Our ref: DOC20/838219

Senders ref: SSD-8859

**Subject: EES comments on Amended EIS and Response to Submissions for Elizabeth Drive subdivision – SSD-8859 – 1111-1116 Elizabeth Drive Cecil Park**

2 SWALE MATRIX 5M X 5M  
Scale: 1:50  
NOTE: DETAIL IS INDICATIVE ONLY,  
PLANT ALL SPECIES RANDOMLY

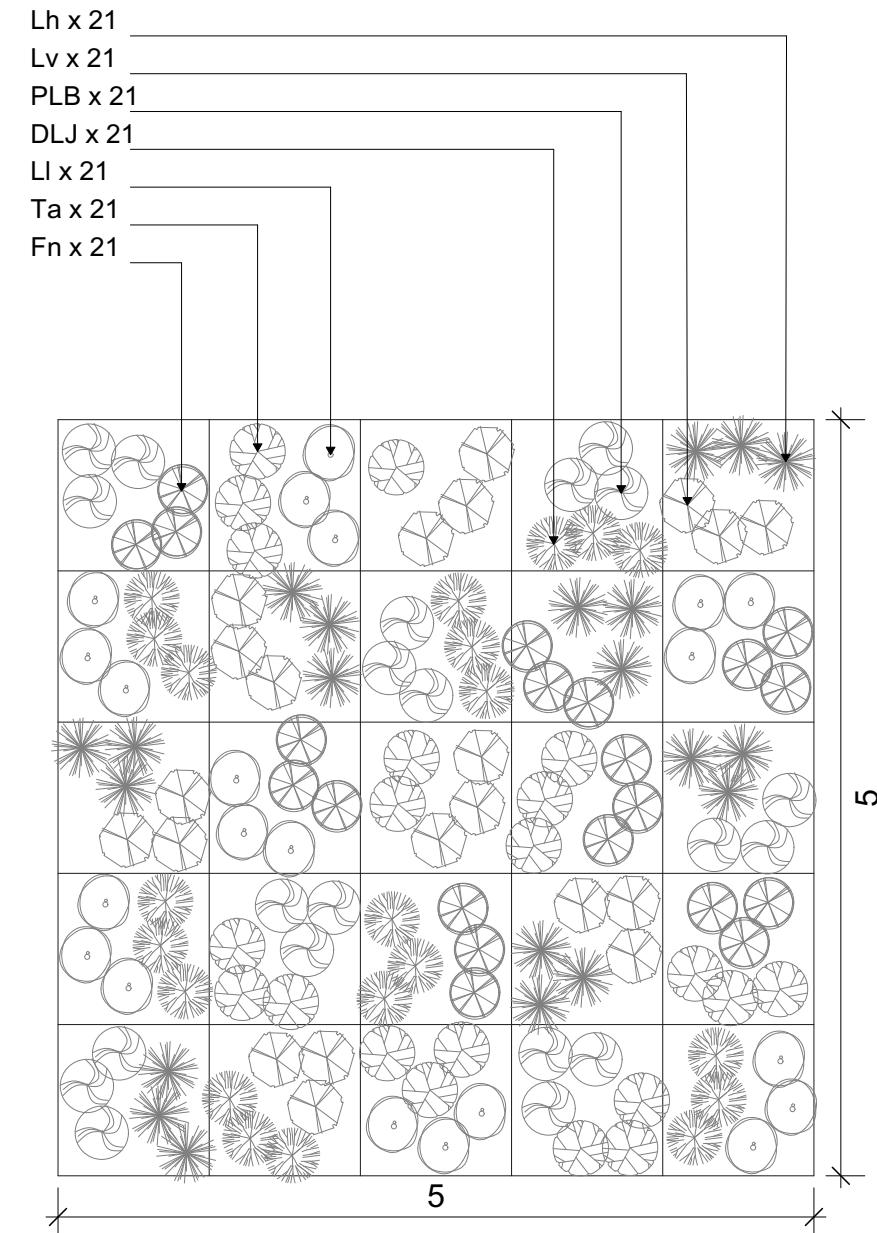
The Urban Design report includes a limited plant species list comprising three tree species (Grey Box, Luscious Water Gum and Forest Red Gum) and seven species of grass and rushes (section

6.7, page 24). EES recommends any landscaping/planting at the site uses a diversity of local provenance native species from the relevant native vegetation communities that occur on the site rather than use exotic species or non-local native species. It is recommended the proponent obtains advice from a suitably qualified bush regenerator on local provenance native plant species that can be planted, and a condition of consent is included to this effect.

- *Any planting for the project shall use a diversity of local provenance native trees, shrubs and groundcover species (rather than exotic species or non-local native species) from the relevant native vegetation communities that occurs on the site*

EARTHWORKS GRADING PLAN		DATA	
DRAWN	CHECKED	DATE	ISSUE
SB	RD	14/08/2020	AI

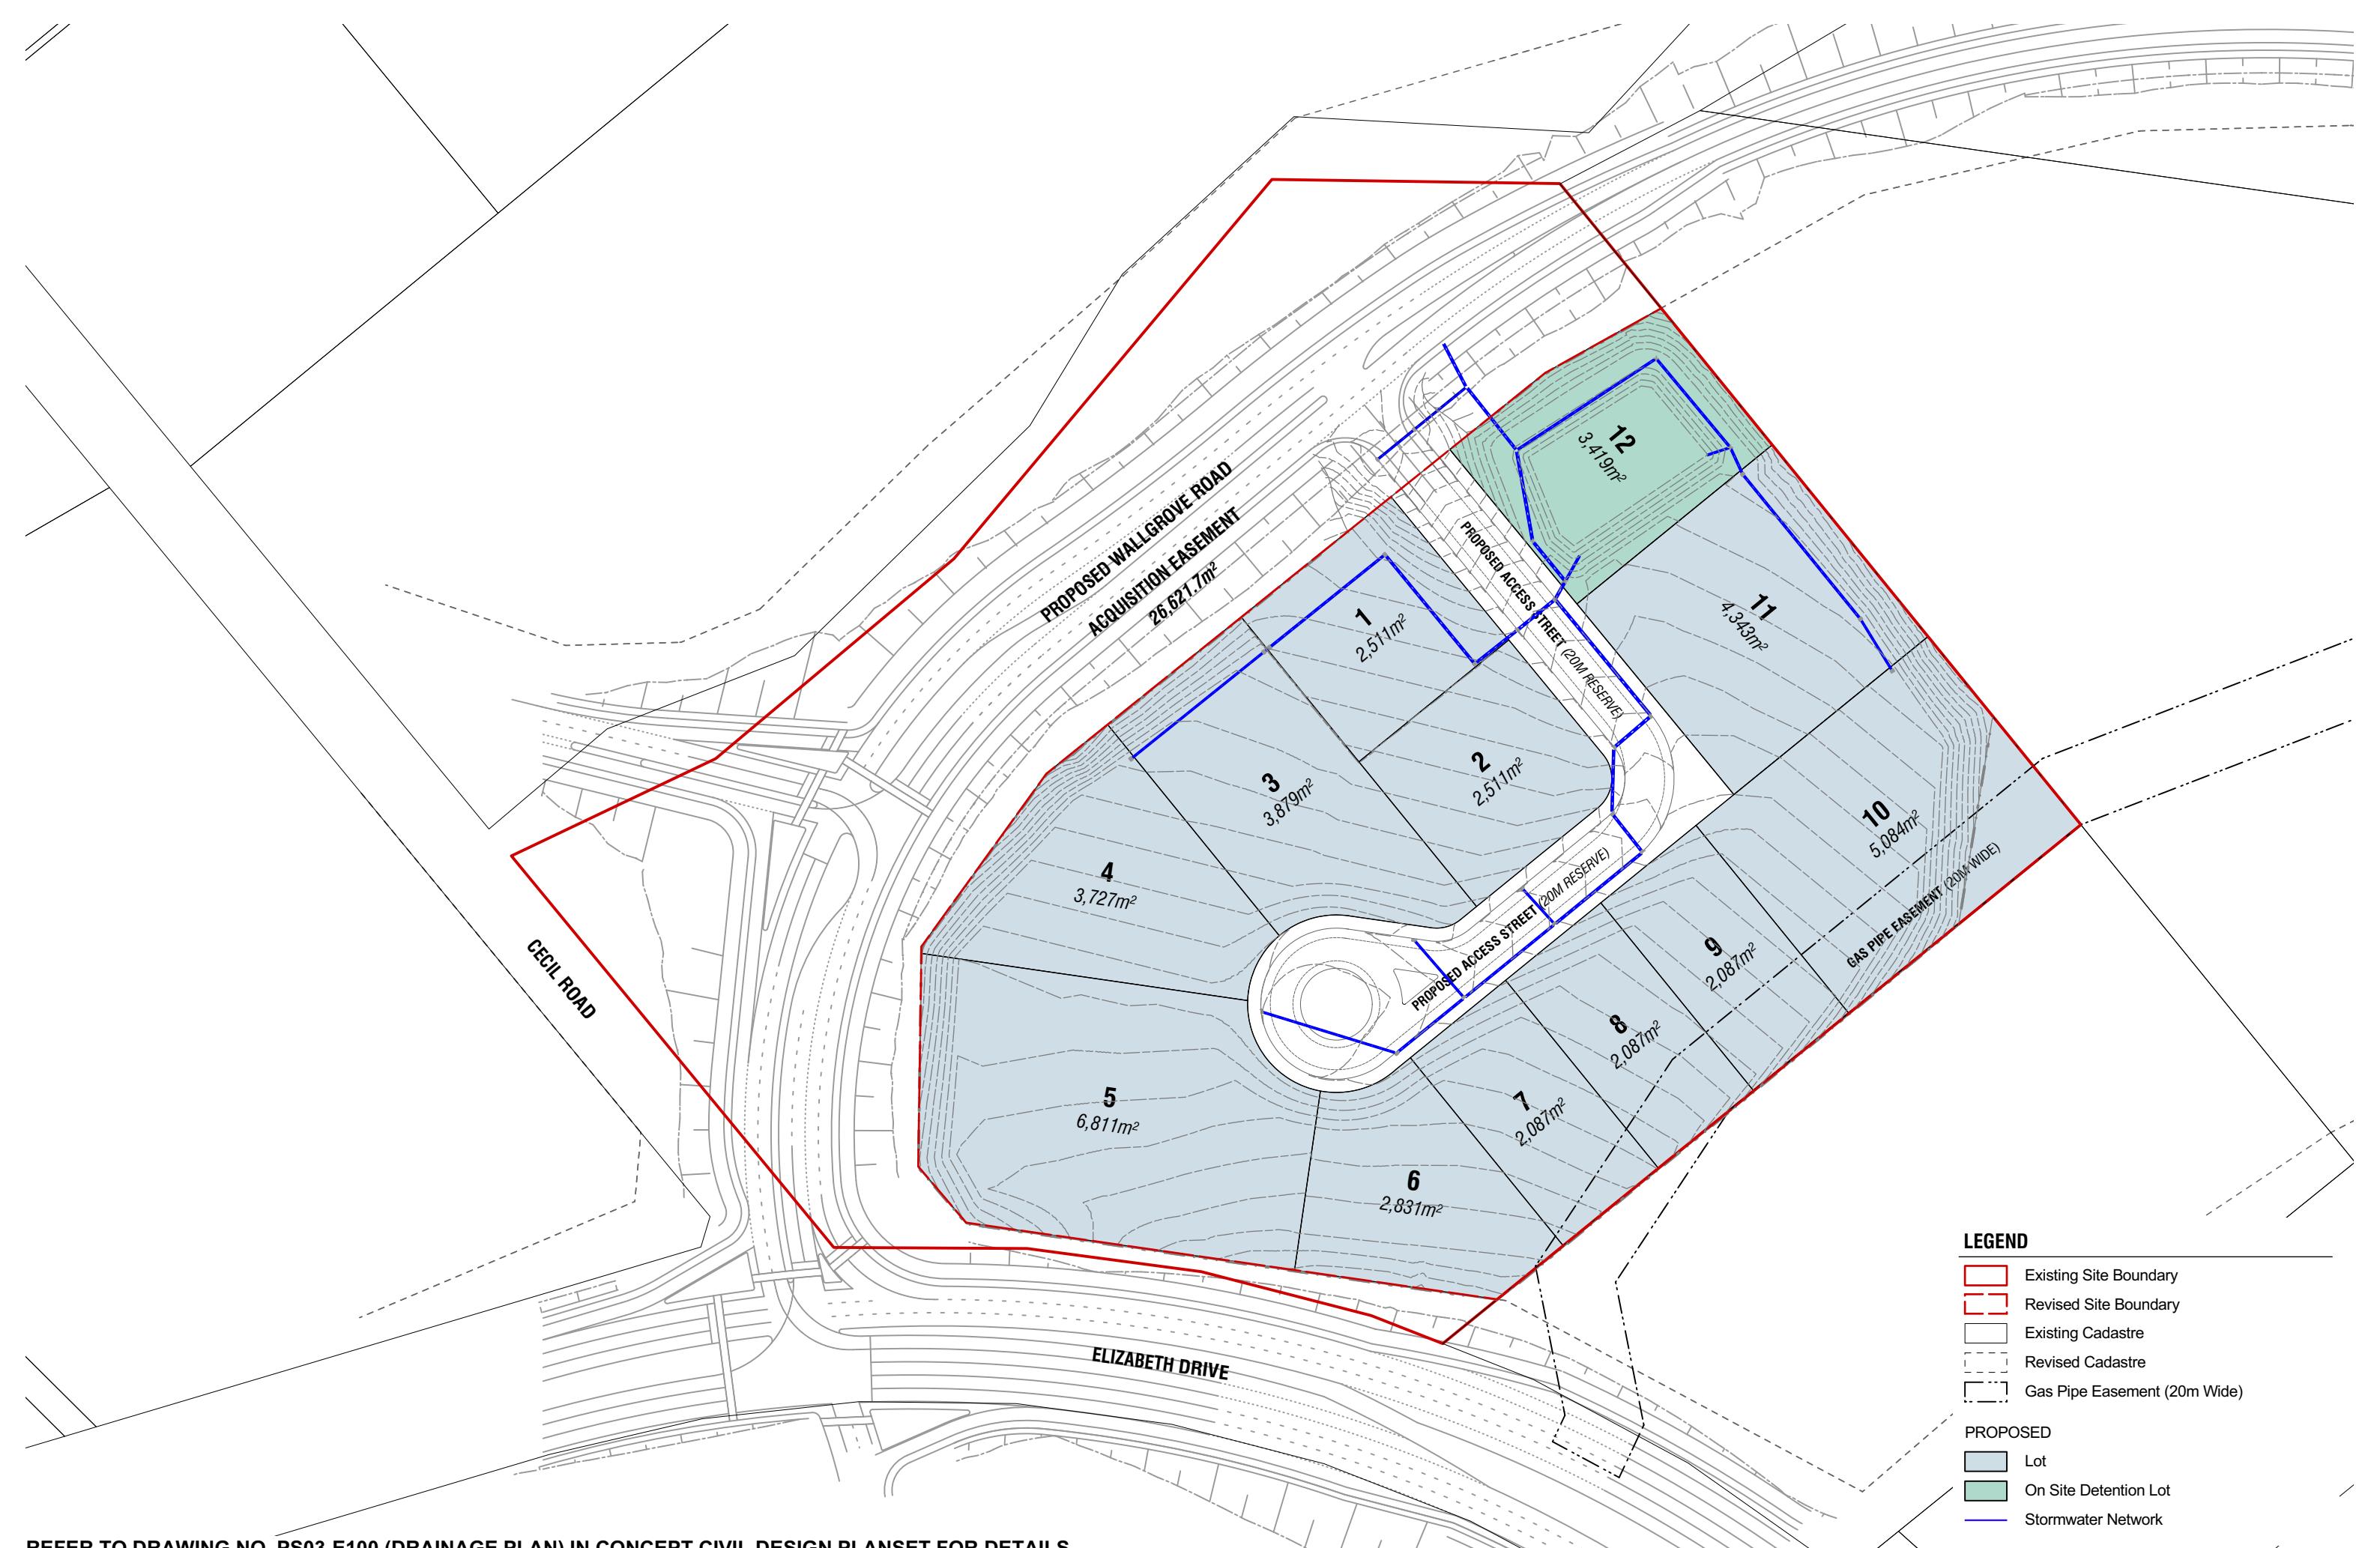
The applicant has not provided the required Flood Impact Risk Assessment for the updated proposal. It is proposed to fill parts of the subject site. There is a risk that this development would cause an unacceptable increase to flood risk on surrounding and downstream properties. Consideration needs to be given to the timing of construction of the Wallgrove Road realignment and the subject development and that these two proposals are independent of each other. The subject development may be constructed before the Wallgrove Road realignment, which may also have impacts not considered as part of EES advice.

A Flood Impact Risk Assessment needs to be prepared, having regard to the revised civil design and EES comments dated 18 March 2019. If information is available on the realignment of Wallgrove Road, two scenarios should be investigated: with and without the road realignment.
